# YARNTON PARISH COUNCIL

20th November 2024

**Re: Application No: 23/02098/OUT - Oxford University Development (OUD) Consultation**

Figure 5.5: Maximum modelled depth in the 0.1% AEP event, 11 hour storm duration

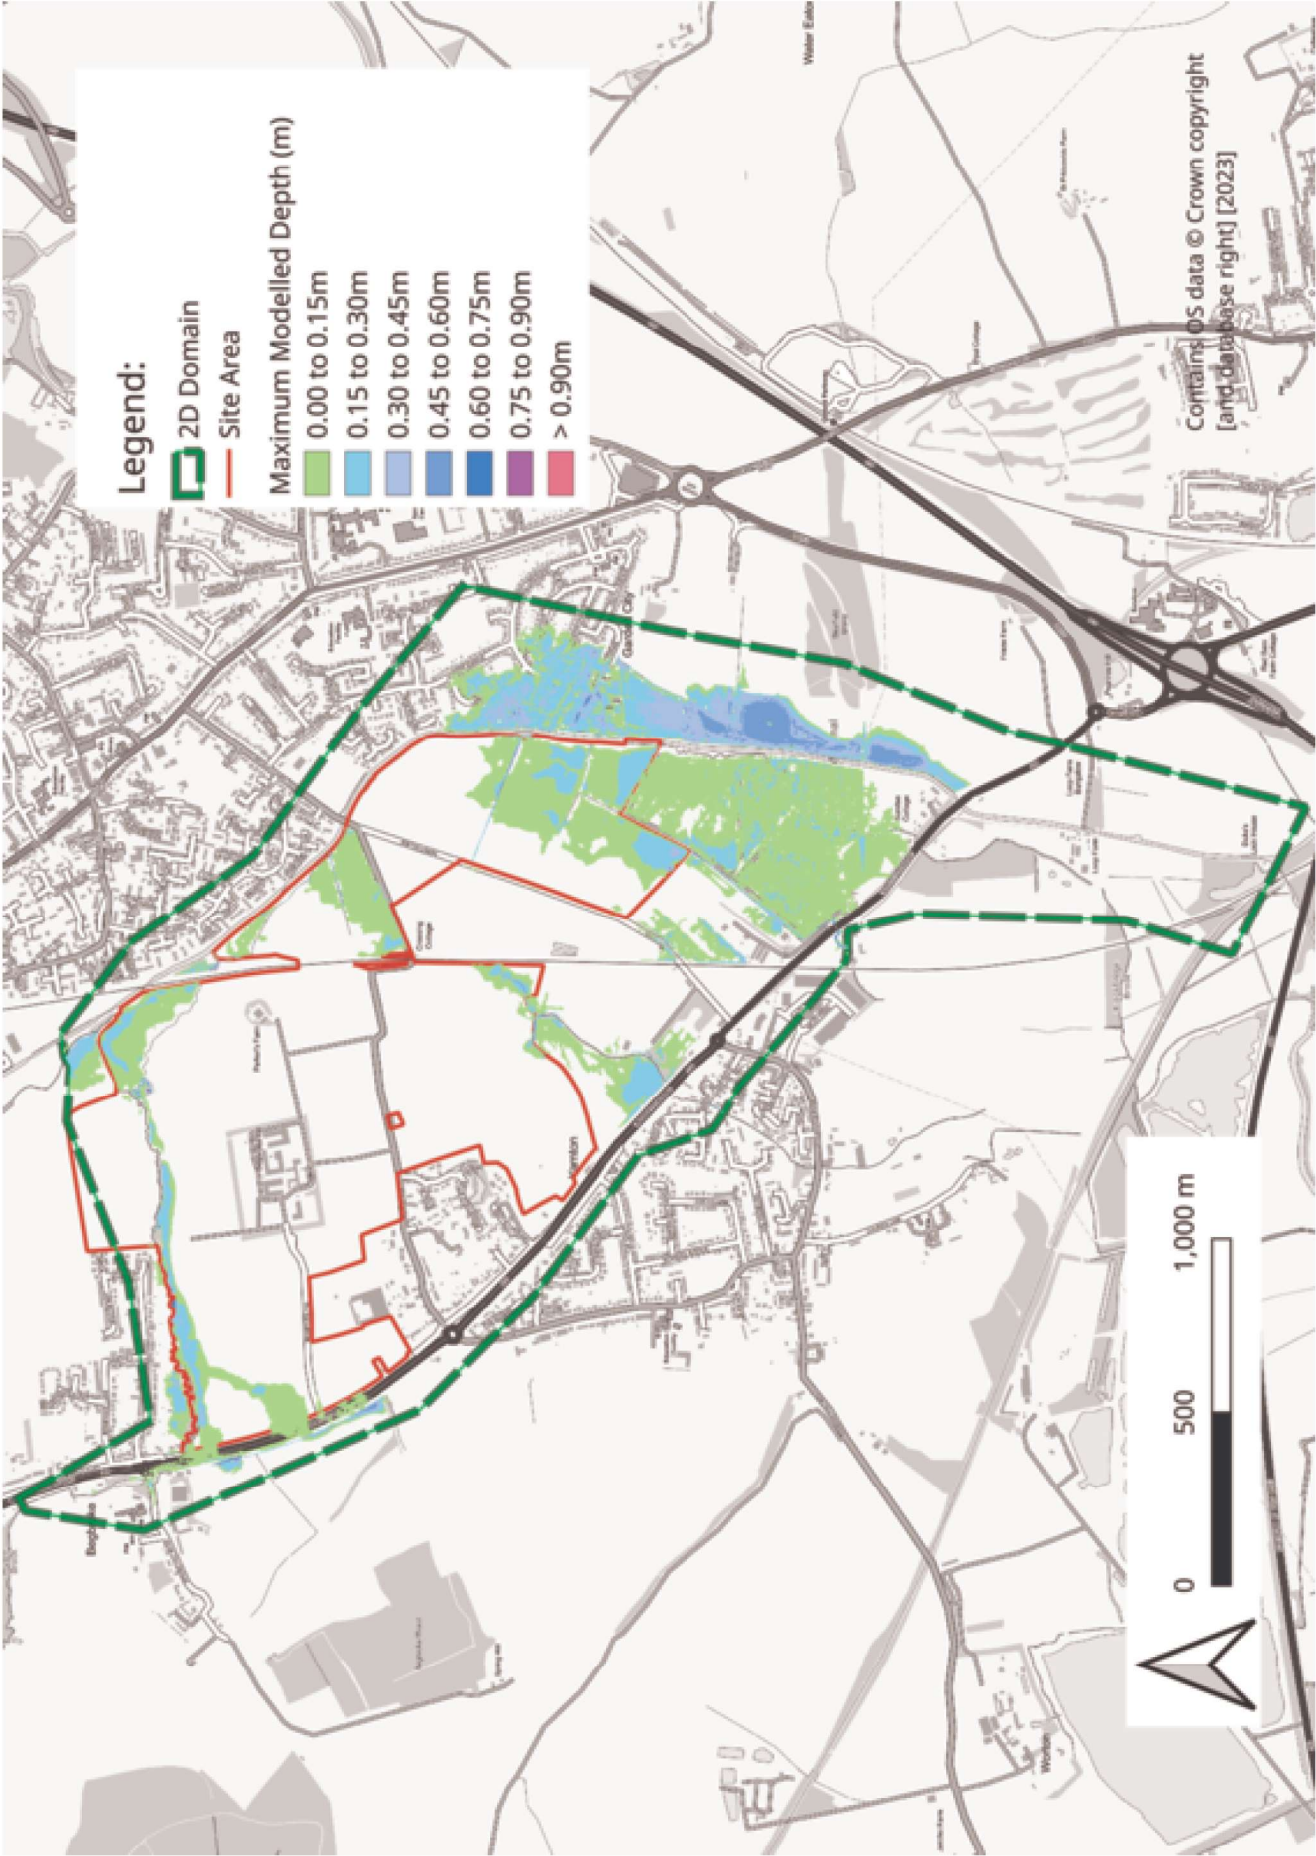
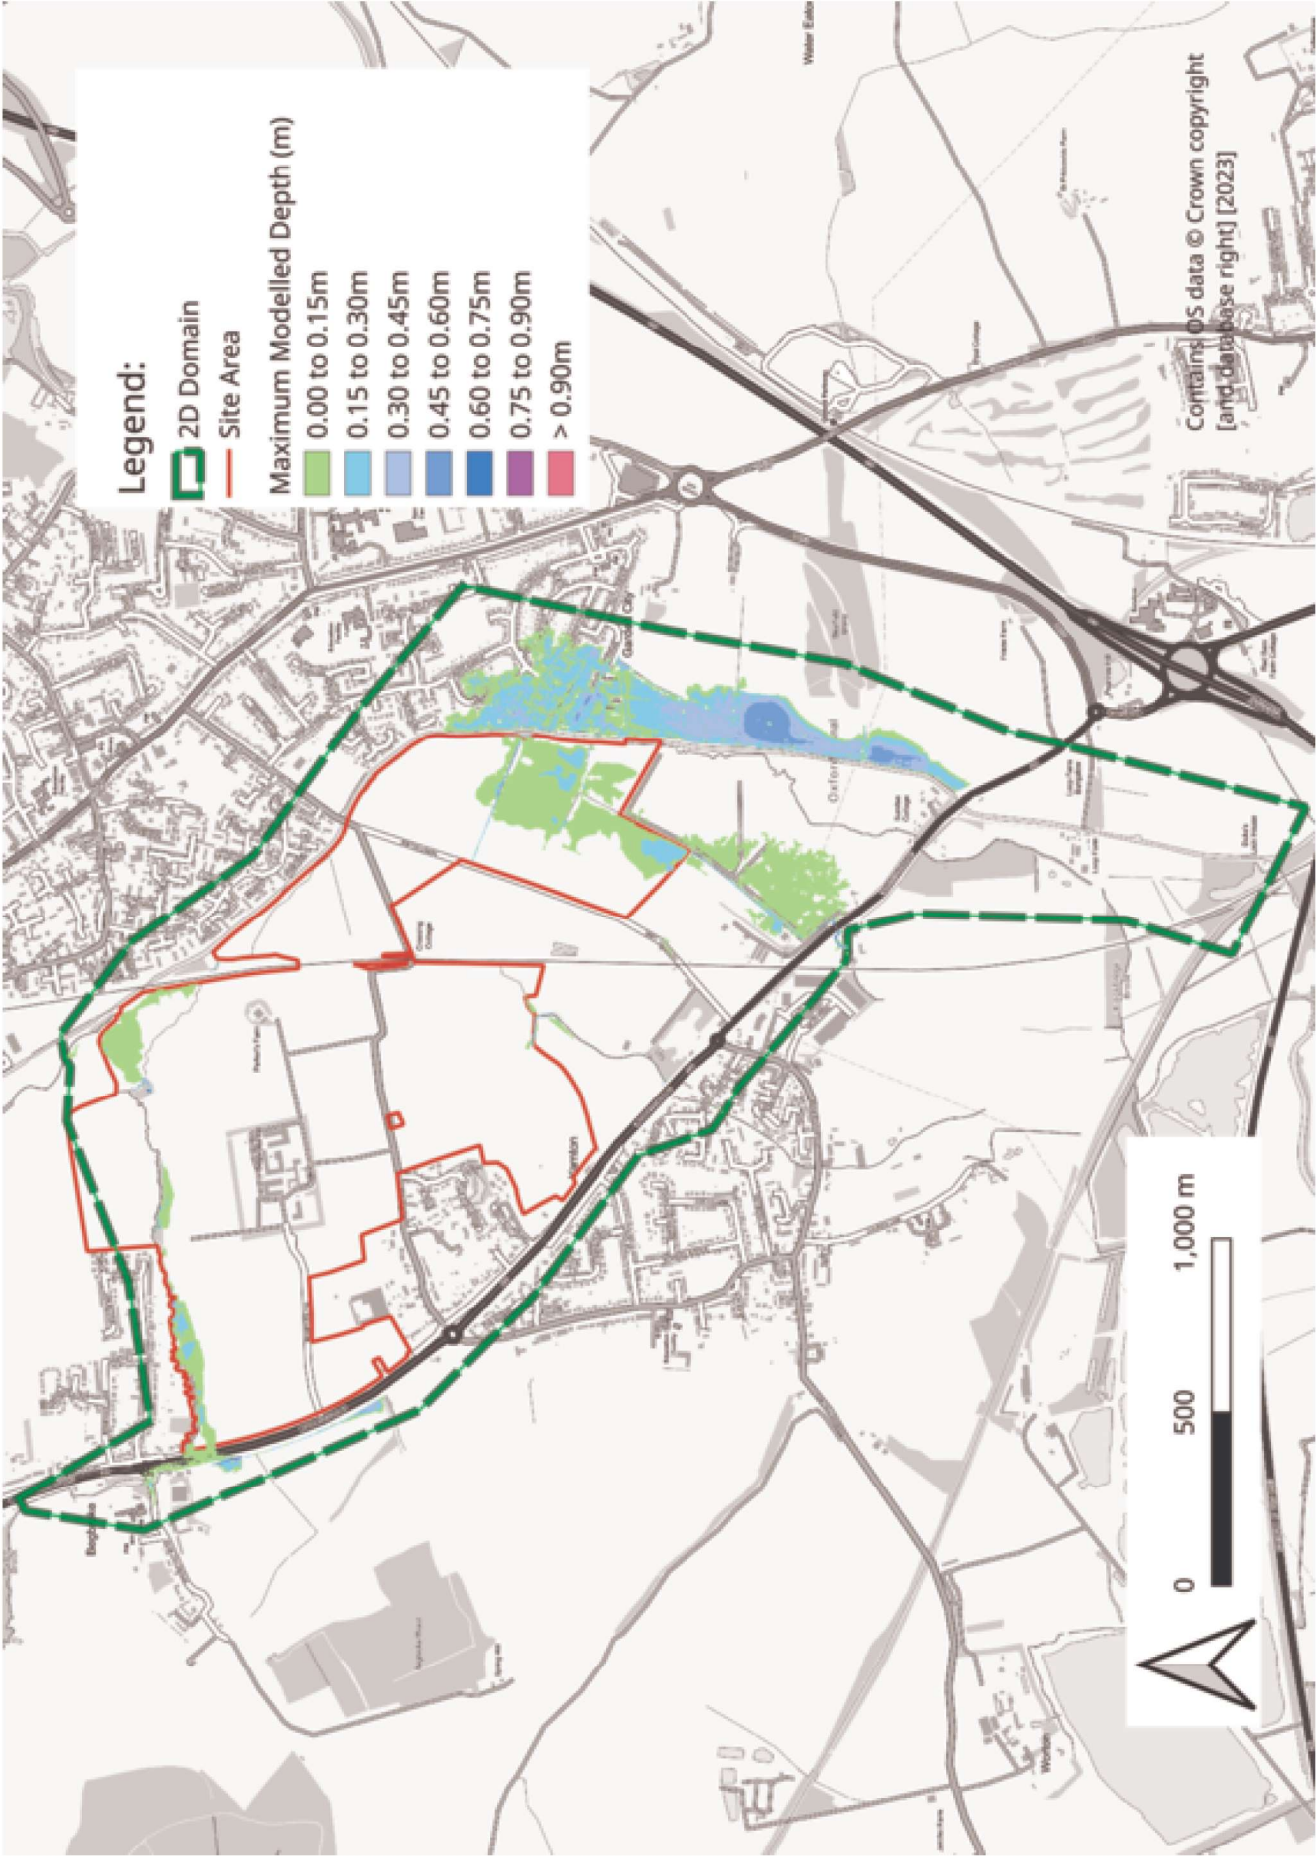
18. The Edenvale report includes a number of flood output maps [Figures 5.1~5.5] which seems to show flooding below a 1 in 100 year return period as very limited. As we said earlier this does not accord with our observations over the last 20 years. Until they have produced a baseline model which is more closely aligned with empirical observations, we do don't consider they are able to produce a design which will deliver the 1 In 100 return period risk which is required.

19. An interesting feature of the flood output maps [Figures 5.1~5.5] is they consistently show a large area of flooding east of the canal; the Stratfield Break and Garden City areas in Kidlington. Those areas rely upon a 200 year old inverted siphon in an unknown condition for drainage and feeding into the Yarnton catchment.
